**Albuquerque
Metropolitan
Arroyo
Flood
Control
Authority**

February 11, 2015

Re: Anasazi Ridge Unit 3 Revised Grading and Drainage Plan, ZAP A-10
Engineer's Stamp Dated 2/2/15

TITLE: **ANASAZI RIDGE UNIT 3
EROSION AND SEDIMENT CONTROL PLAN**

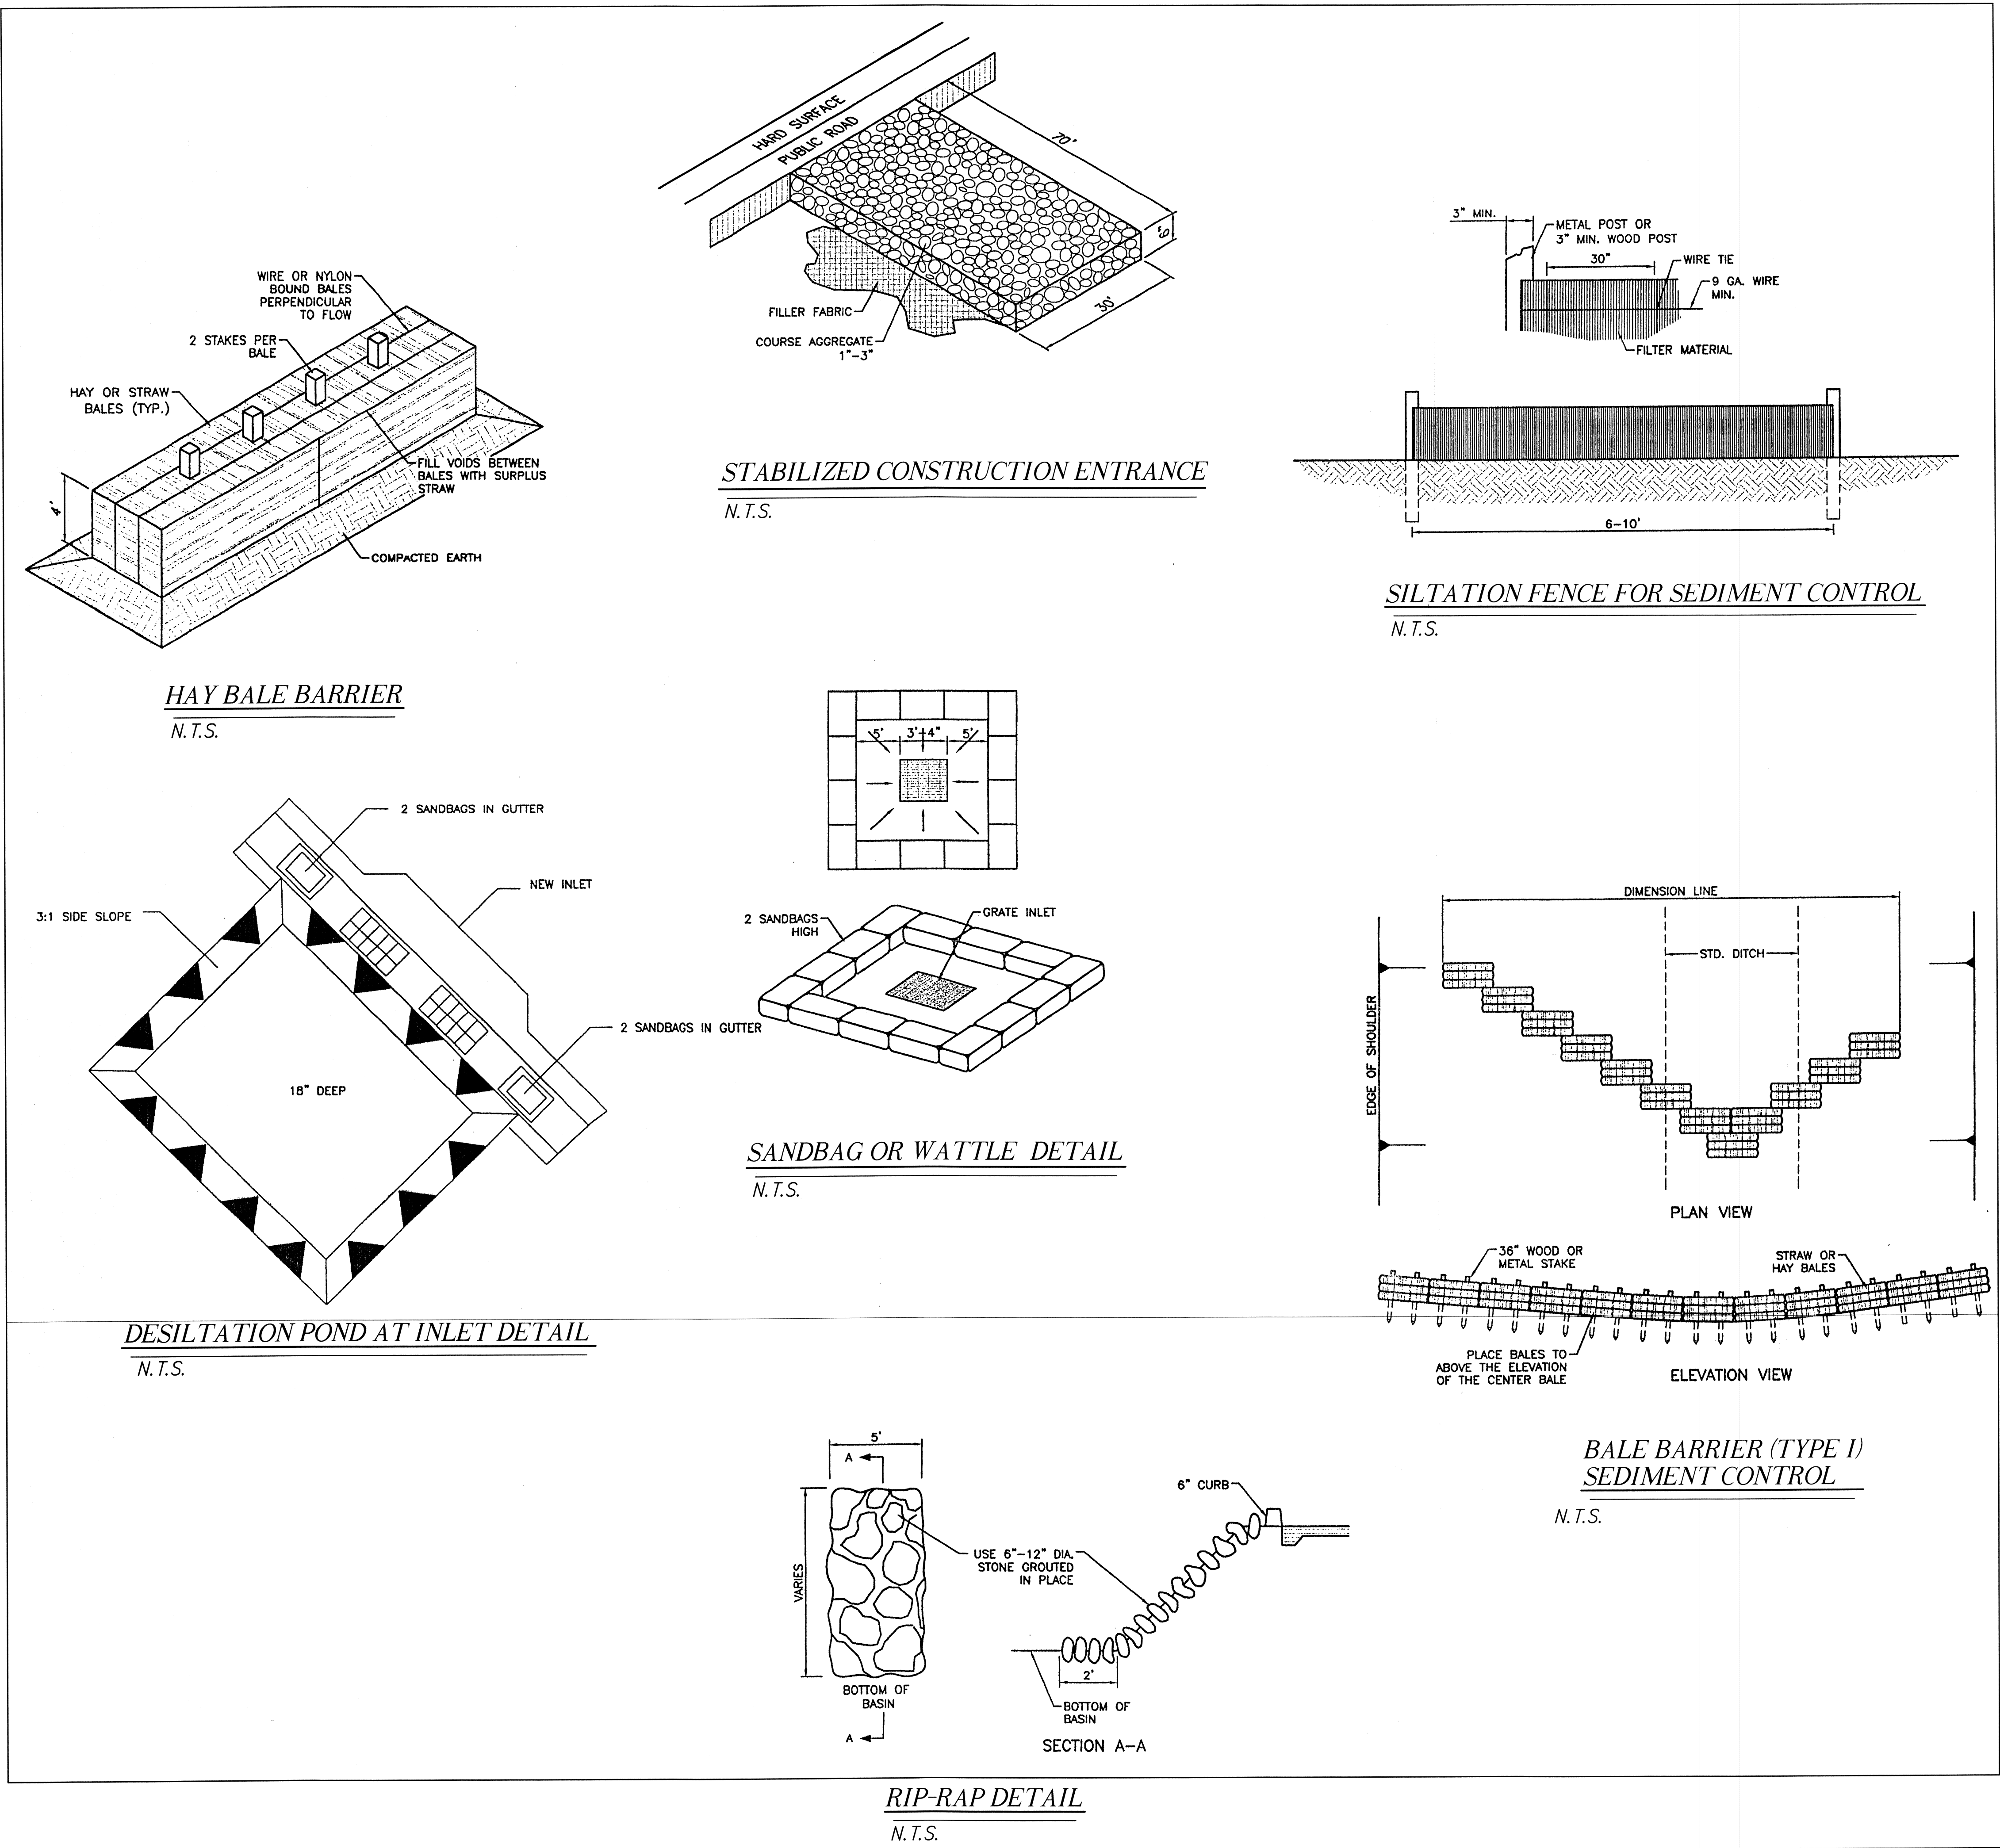
1. The discharge from the end of the asphalt swale will be highly erosive and potentially damaging to private property at velocities higher than 3 feet per second. A riprap or concrete swale should be extended to the soil cement on the Calabacillas Arroyo.
2. The temporary asphalt channel rundown from the intersection could be there for several years. Asphalt channels degrade after a few years as evidenced by the ones along Rio Bravo Boulevard west of I-25 and along north Tramway Boulevard. AMAFCA recommends the rundown be constructed with riprap or concrete.
3. On page 6 of the Drainage Report dated 10-24-14, the 100-year flow rate from the intersection is stated to be 47 cfs. The calculations in Appendix C are for 18 cfs. Please clarify.
